Construction Noise and Vibration review for SSD-30759158

Construction Noise And Vibration Report-- Day Design

I refer to Report 7280 – 1.3R Construction Noise & Vibration Dated 14th April 2022 Prepared by Day Design Pty Ltd: I have little experience in building and construction projects but have considerable experience with regard to trucks and transport equipment and mining logistics.

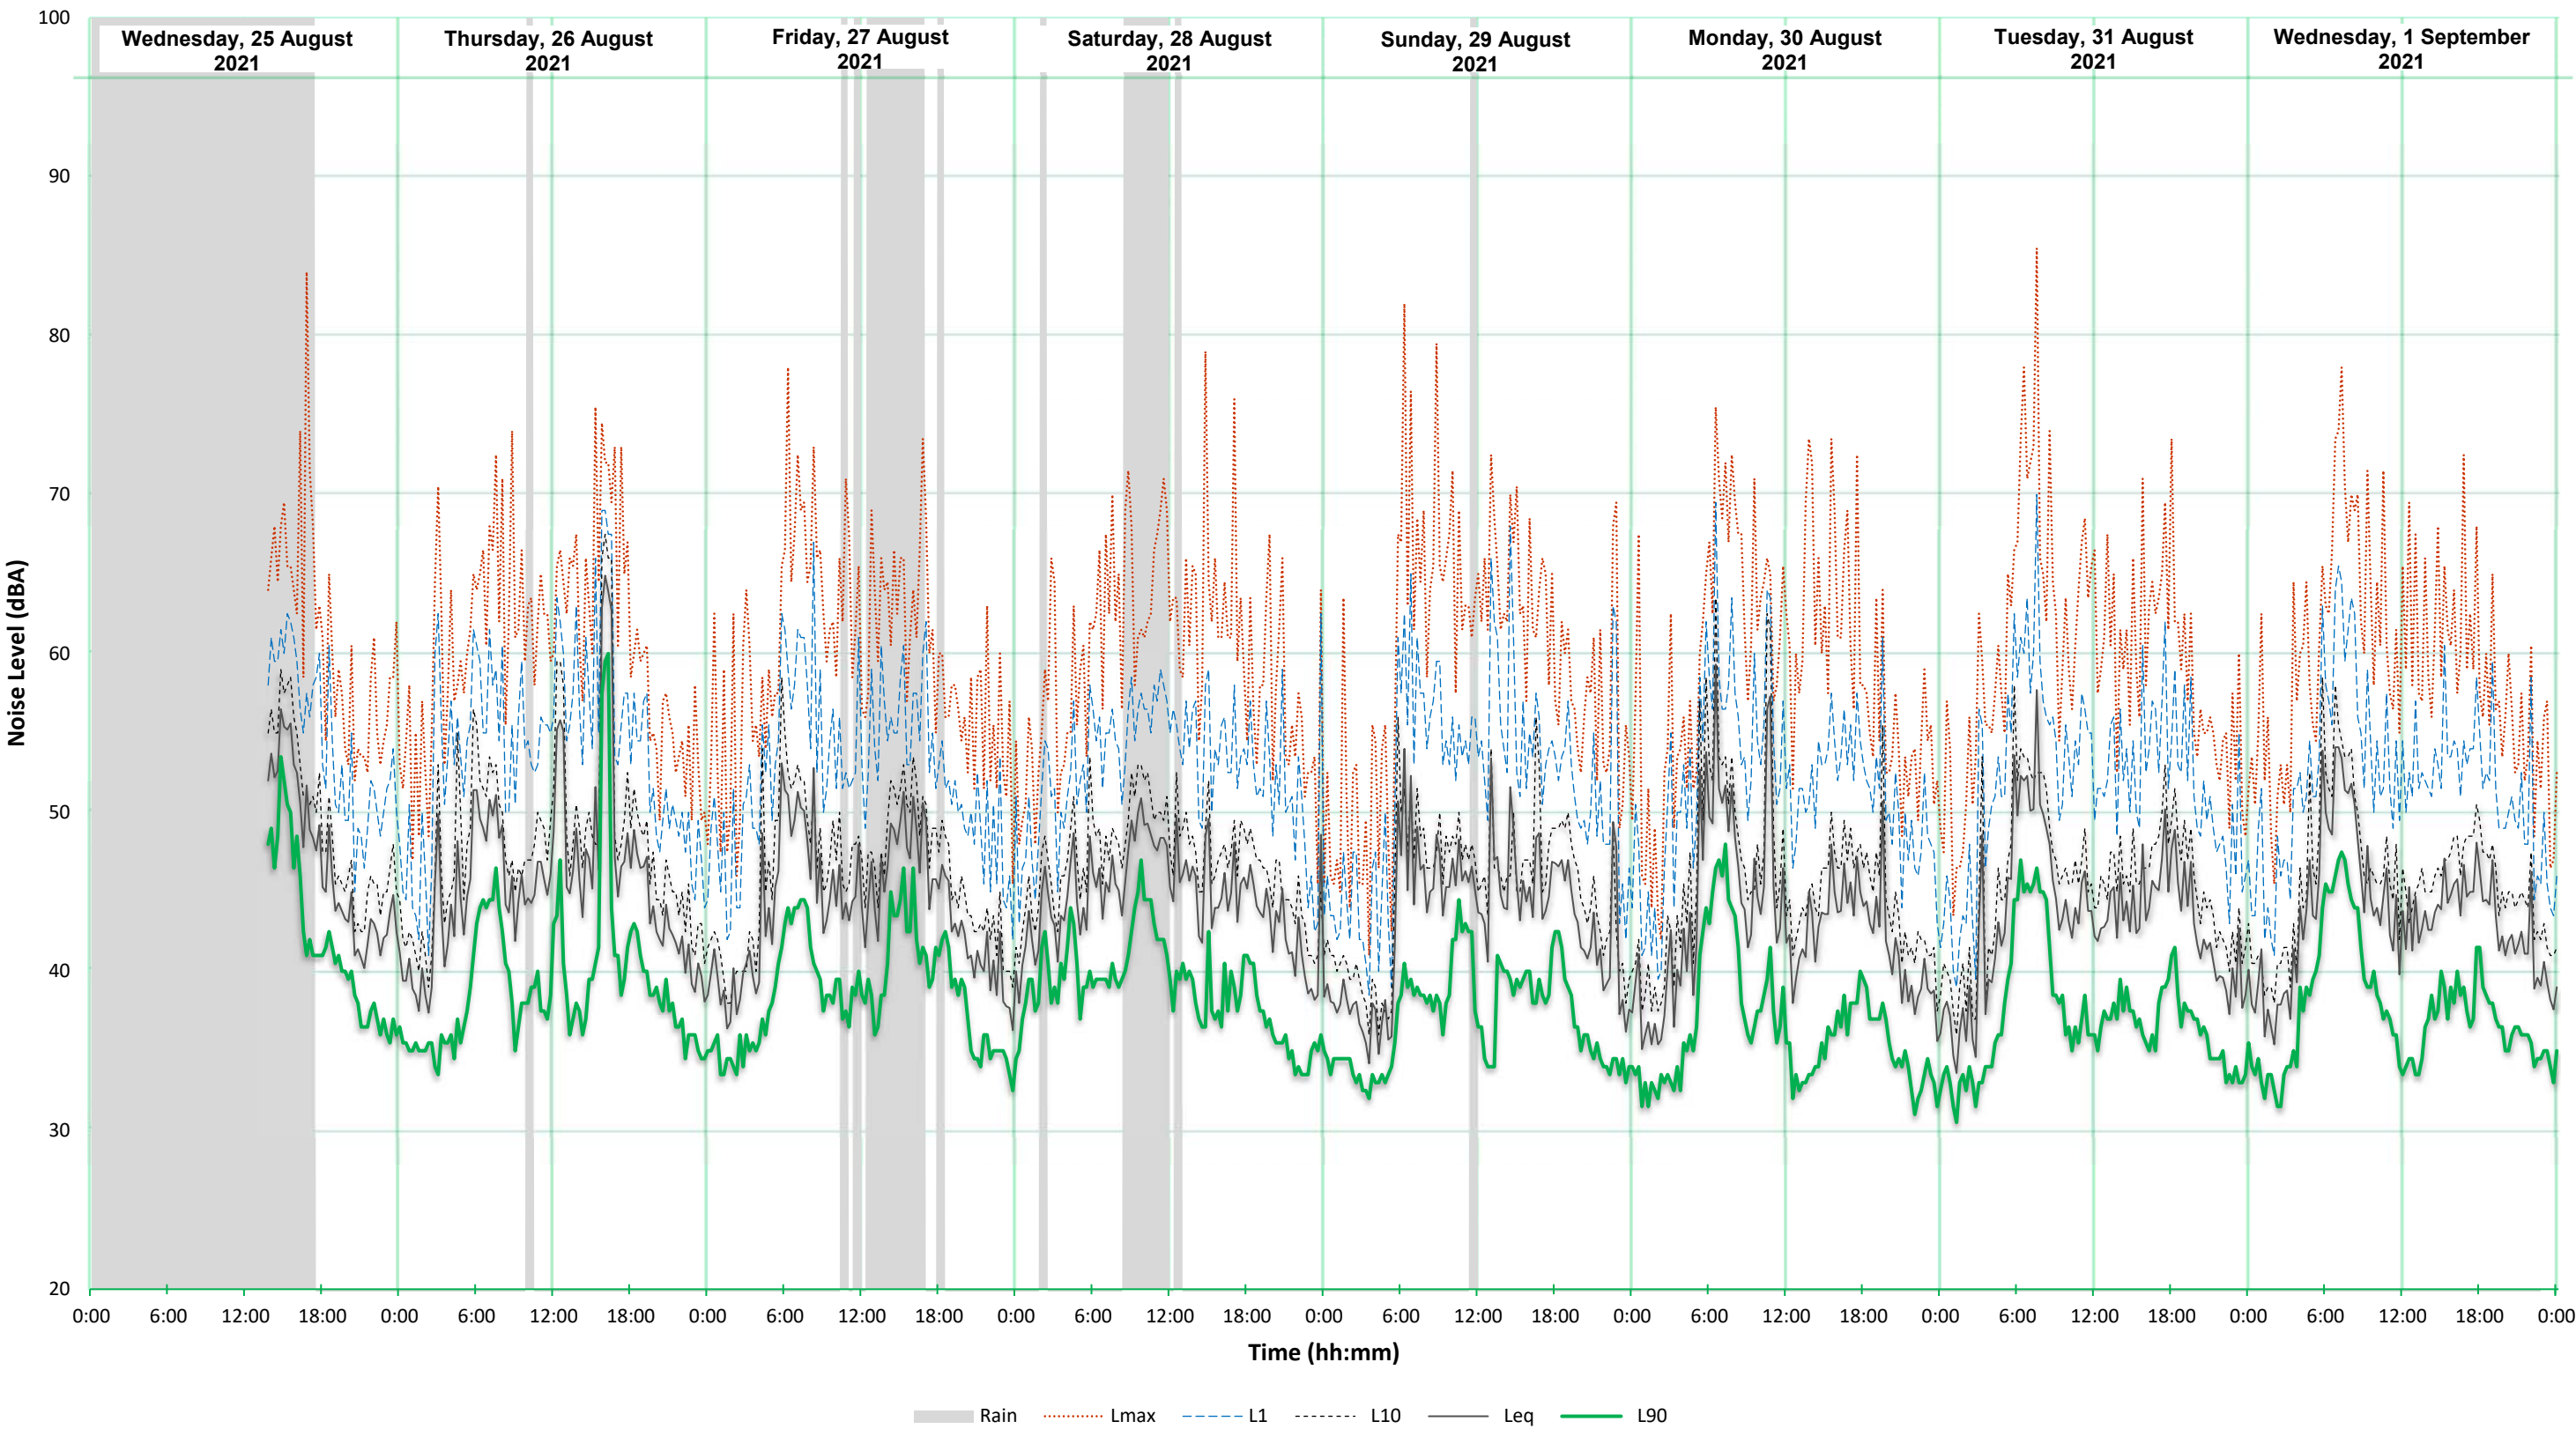
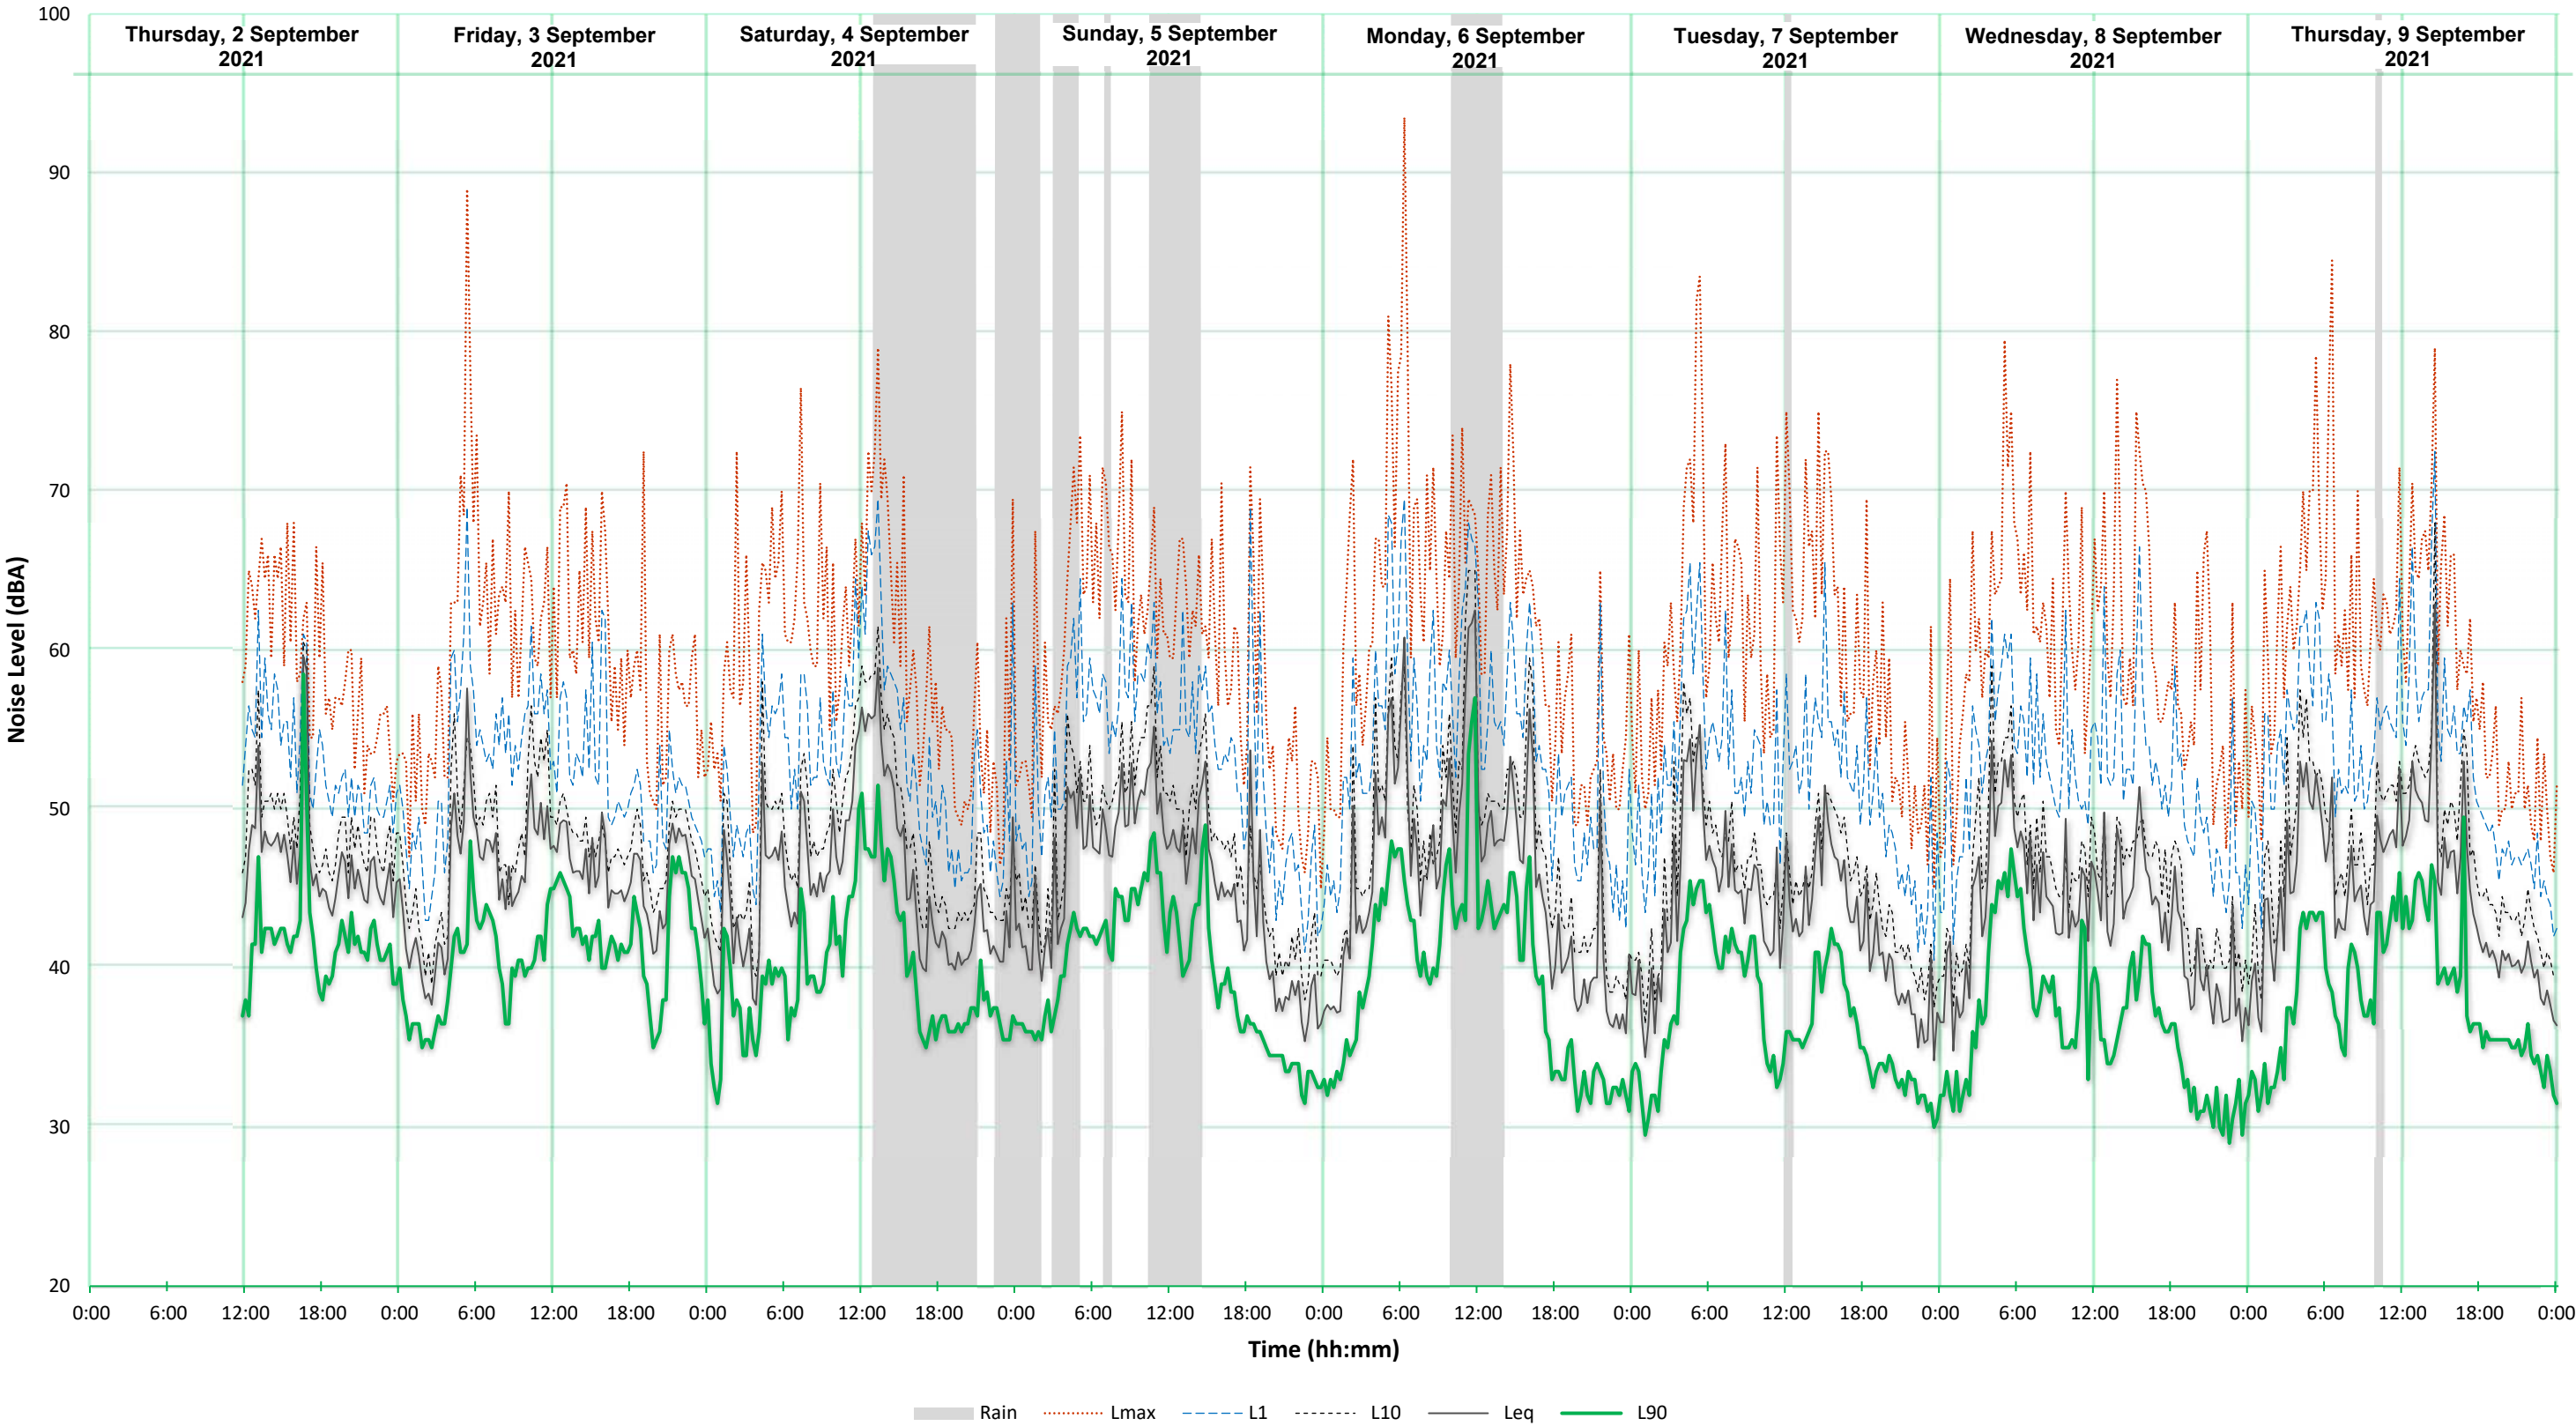
I note at the bottom of P13, 5.1 there is a reference to the data logger in position A being stolen and never recovered containing data between Wednesday 25th August and 2nd September.

Table 3 on p14 shows results for that same period. One of these statements must therefore be false and misleading. How can you show data that you supposedly don’t have?

I also note that there is data in Table 3 purporting to be between 15th September and 22nd September but there is no supporting data in Appendices B1, B2, B3, B4 for these dates also.

At the bottom of p14 referring to Table 3 a statement about meteorological conditions appears contradictory as it talks about “where applicable rain or wind affected data has been removed from the assessment period” Given that the data in Appendices B1-B4 has a mixture of rain affected days and clear days it is confusing at best. Dates not covered in Table 3 also have a mixture of wet and dry days causing one to wonder if the dates used have been cherry picked to achieve a specific set of numbers?
